**KIRKLEES METROPOLITAN COUNCIL
INVESTMENT & REGENERATION SERVICE**

Reference No: 2021/62/92998/E

Site Address: 1, Swincliffe Gardens, Birkenshaw, BD19 4BR

Description: Erection of single storey rear extension, increase in roof height and exterior alterations

Notes :-

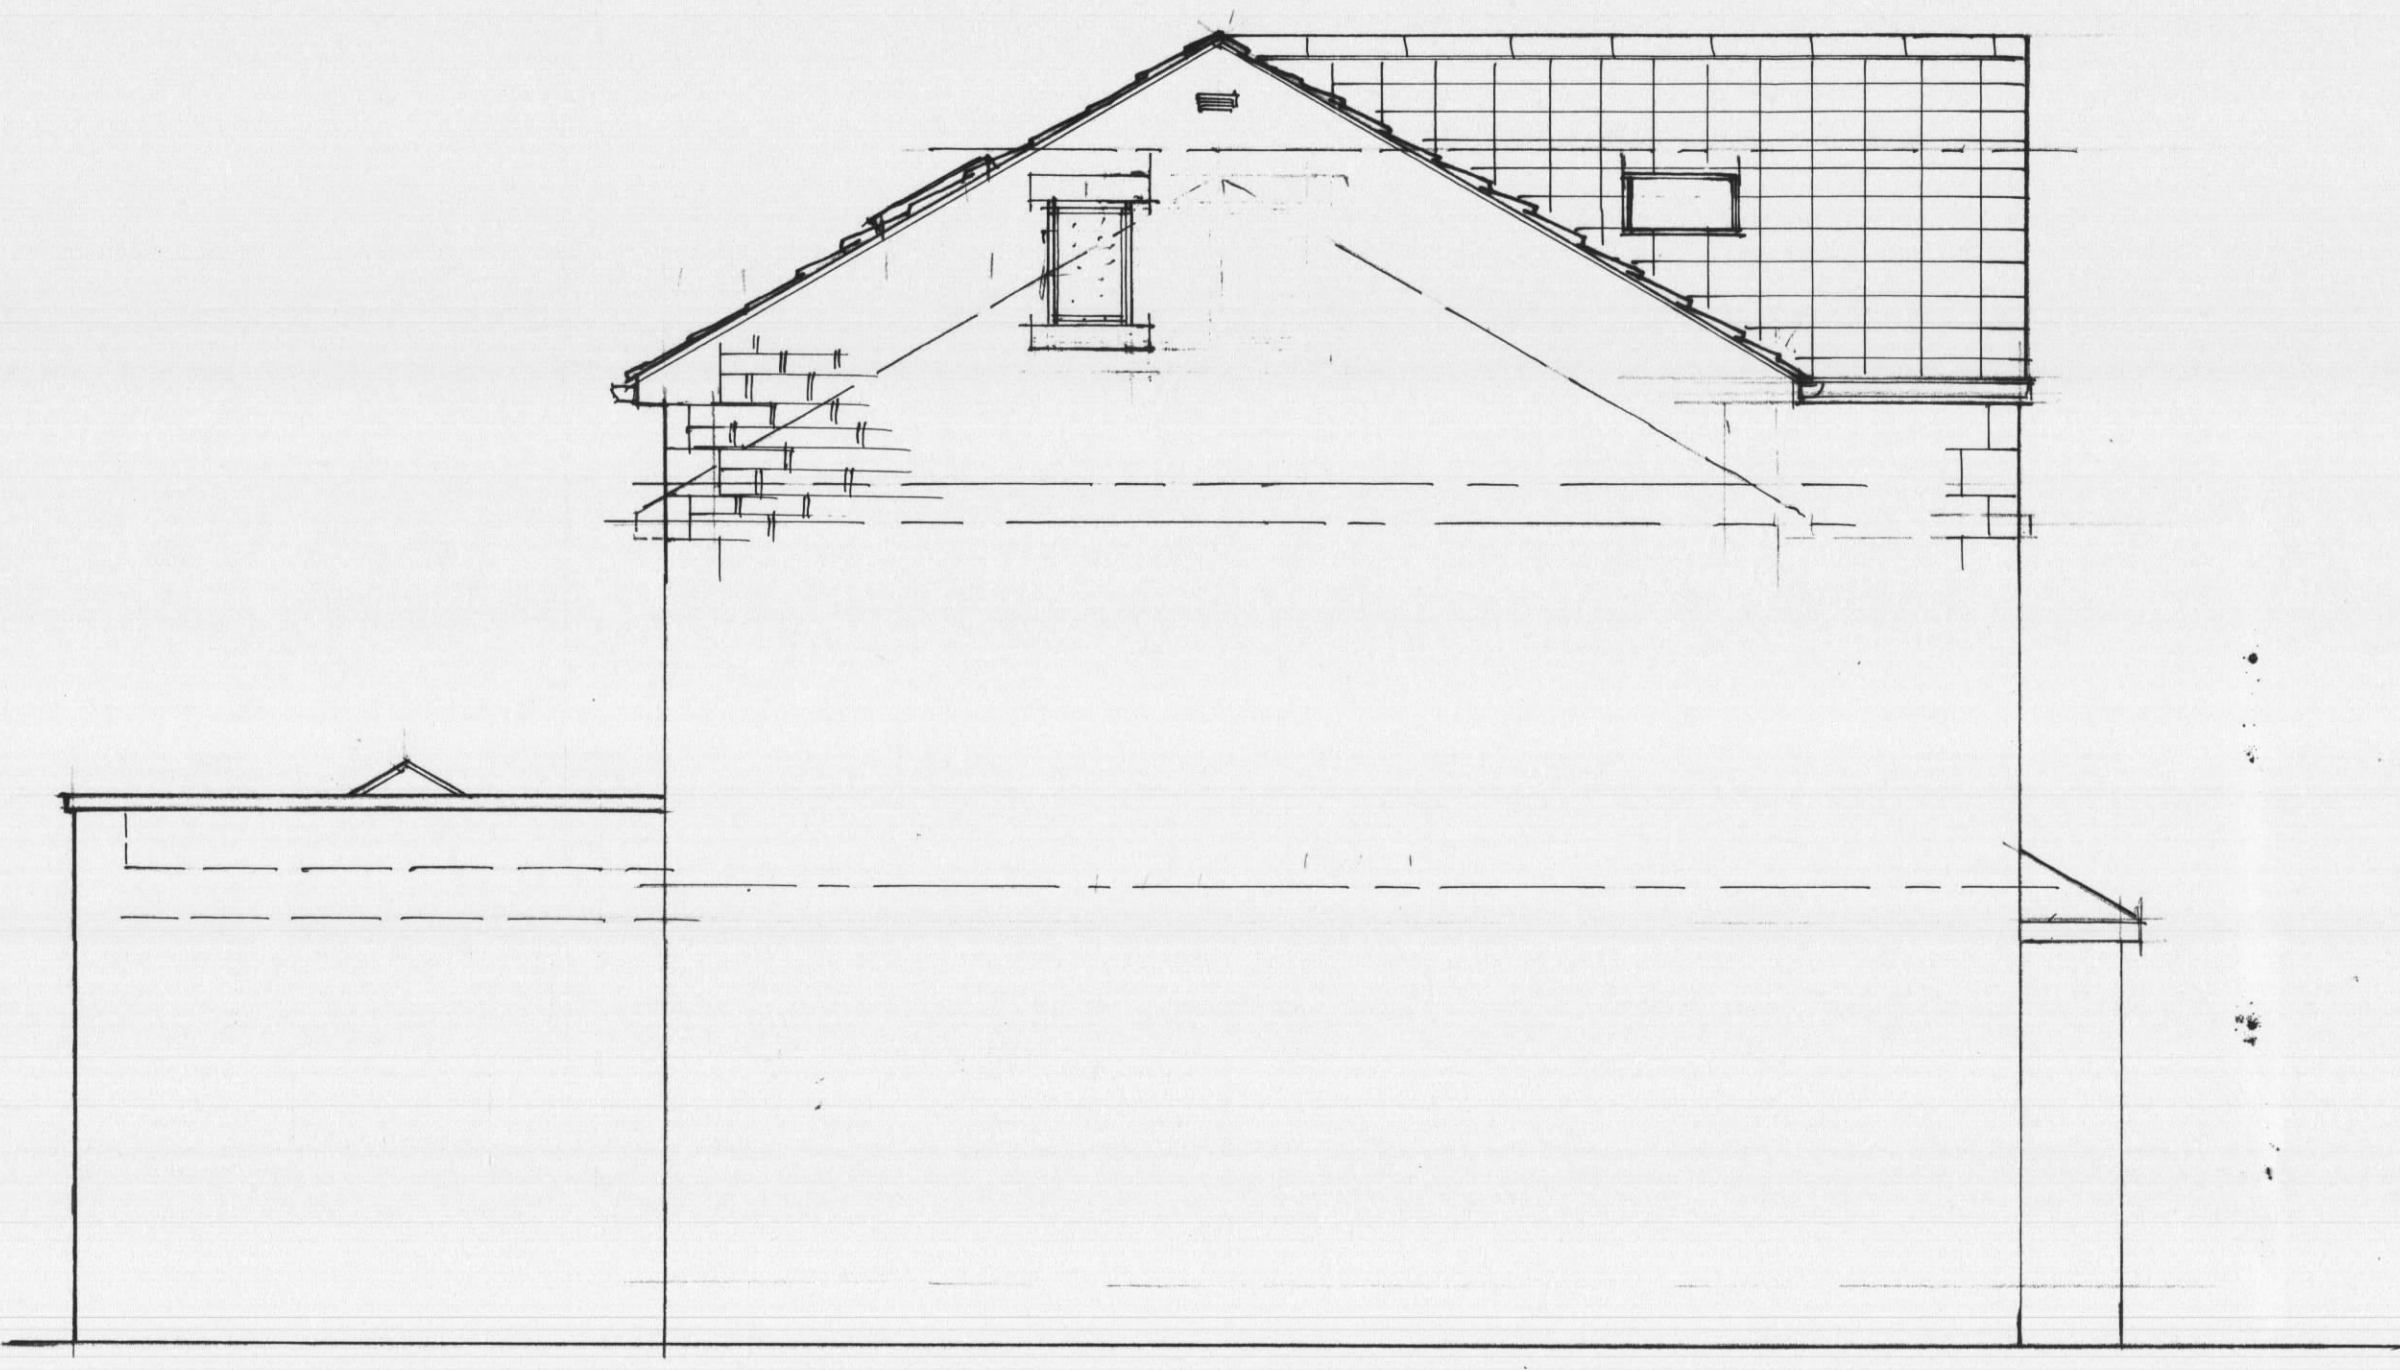
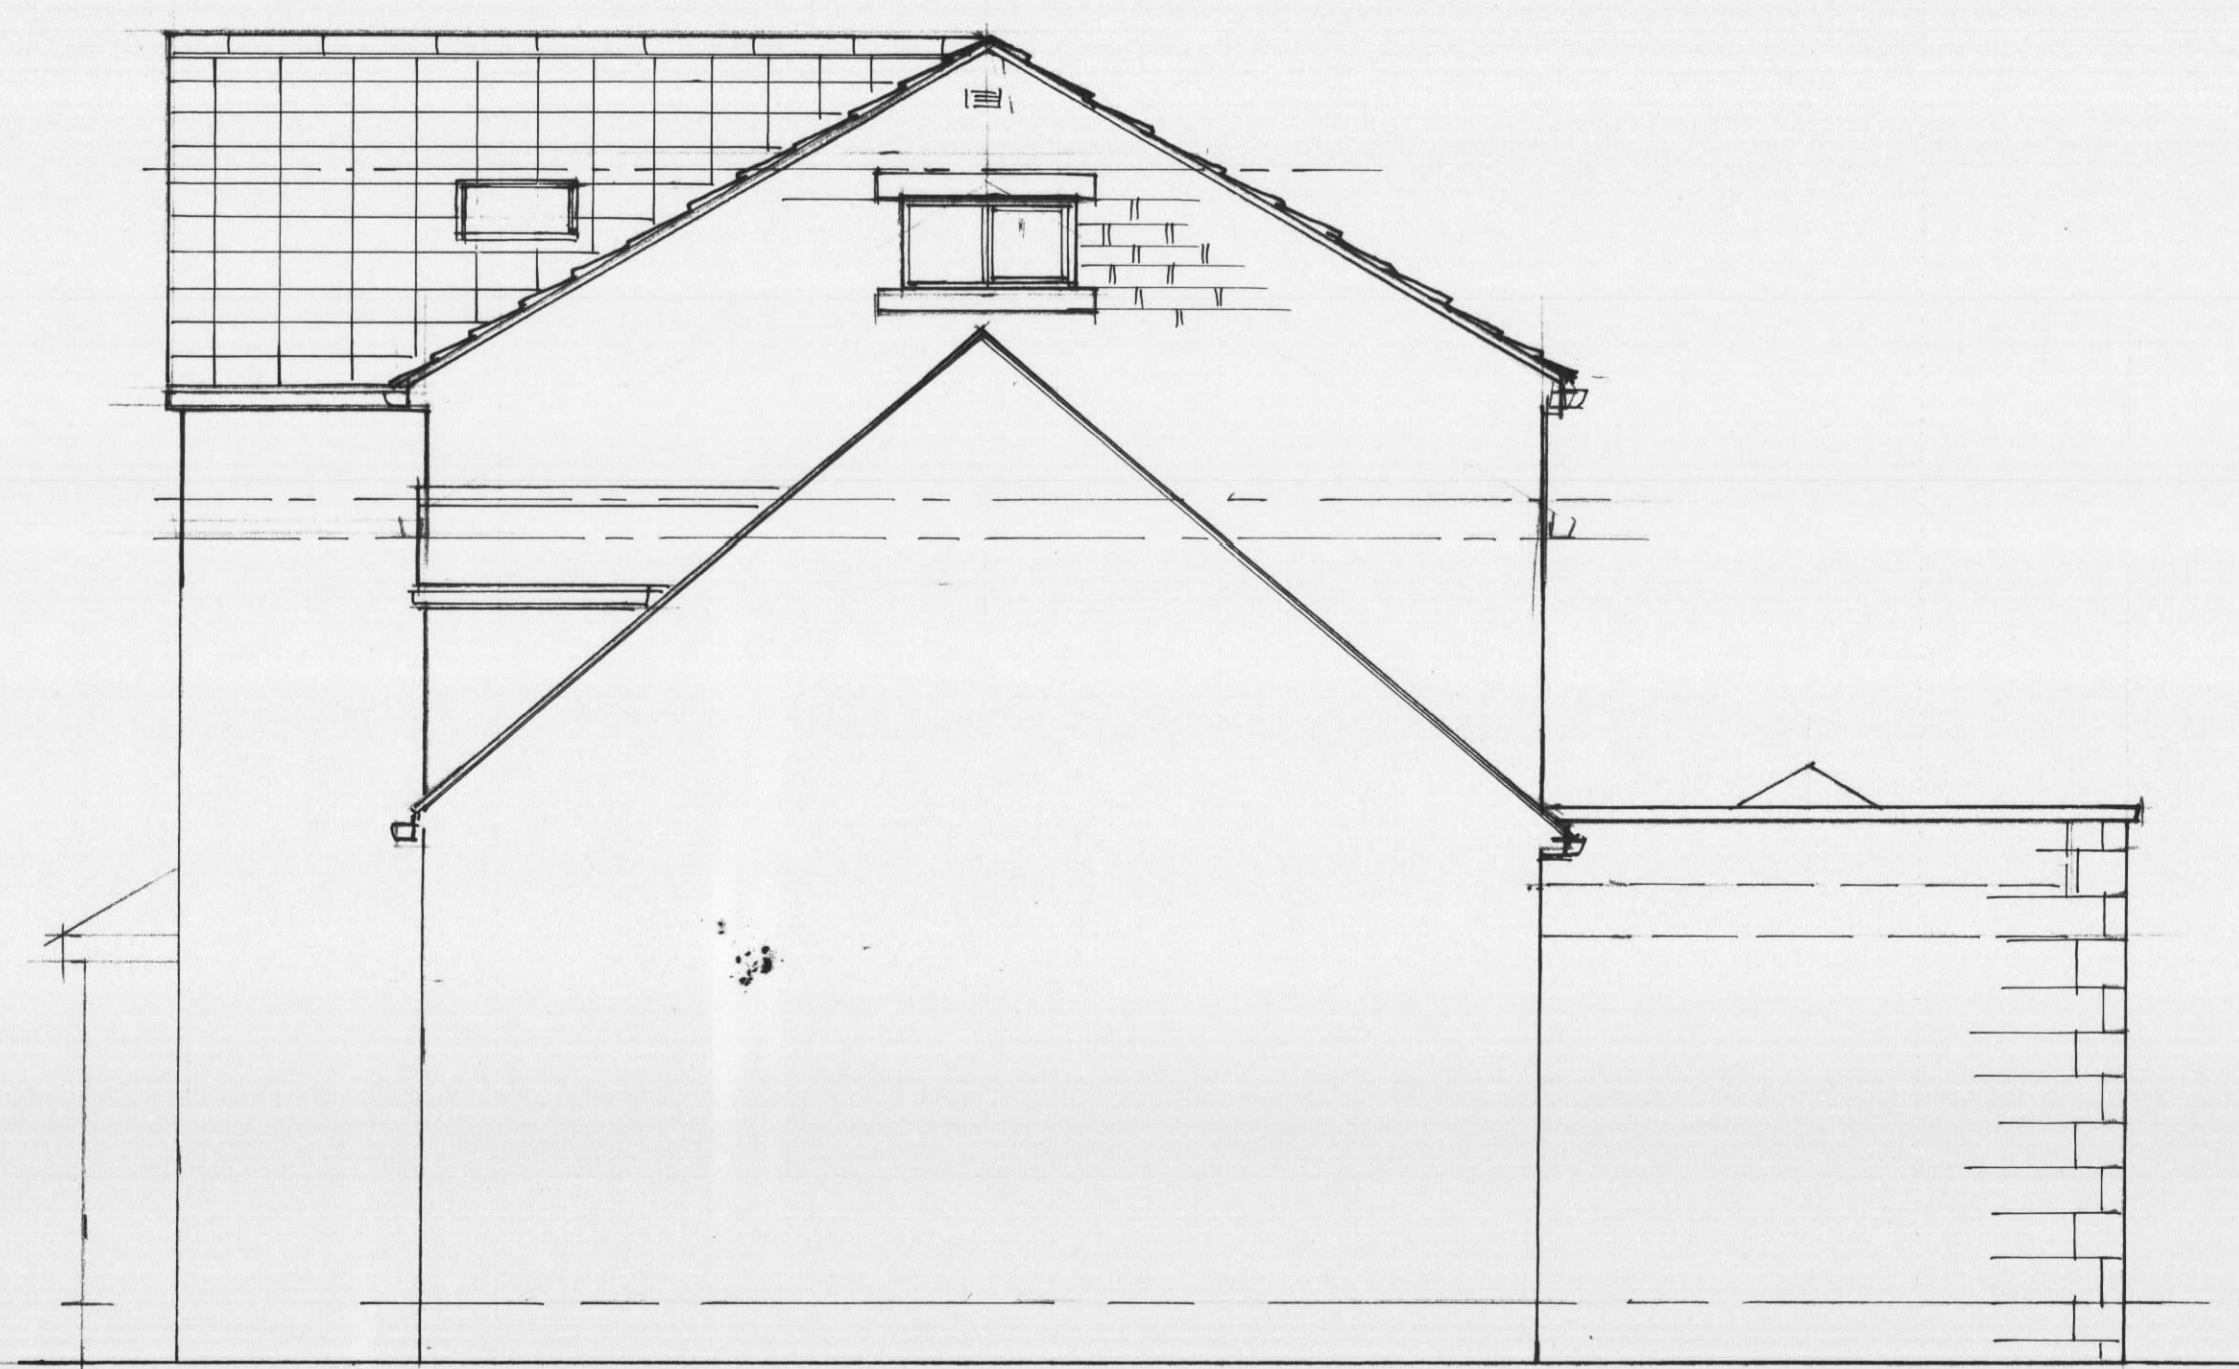
The house is sited at an angle in comparison with the housing development further west at Swincliffe Gardens and sufficient space would exist about the plot to visually absorb the increase in massing, such that the increase in height would

not appear incongruous. Similarly, the building line is broken by the angle of the front elevation and the roof ridge would not appear out of keeping in terms of the street scene when viewed from Bradford Road. The proposed rear extension would replace the conservatory element and would accord with the guidelines for such additions as set out in the SPD on house extensions.

The proposed palette of materials such as stone facing materials would clearly assimilate the proposed rear extension into the host dwelling.

The proposed increase in roof ridge height would not cause overshadowing to any neighbouring properties over and above that of the existing situation thanks to the space about the house in the plot. Likewise the single storey rear extension would not breach 45 degree lines of sight from any neighbouring habitable room windows.
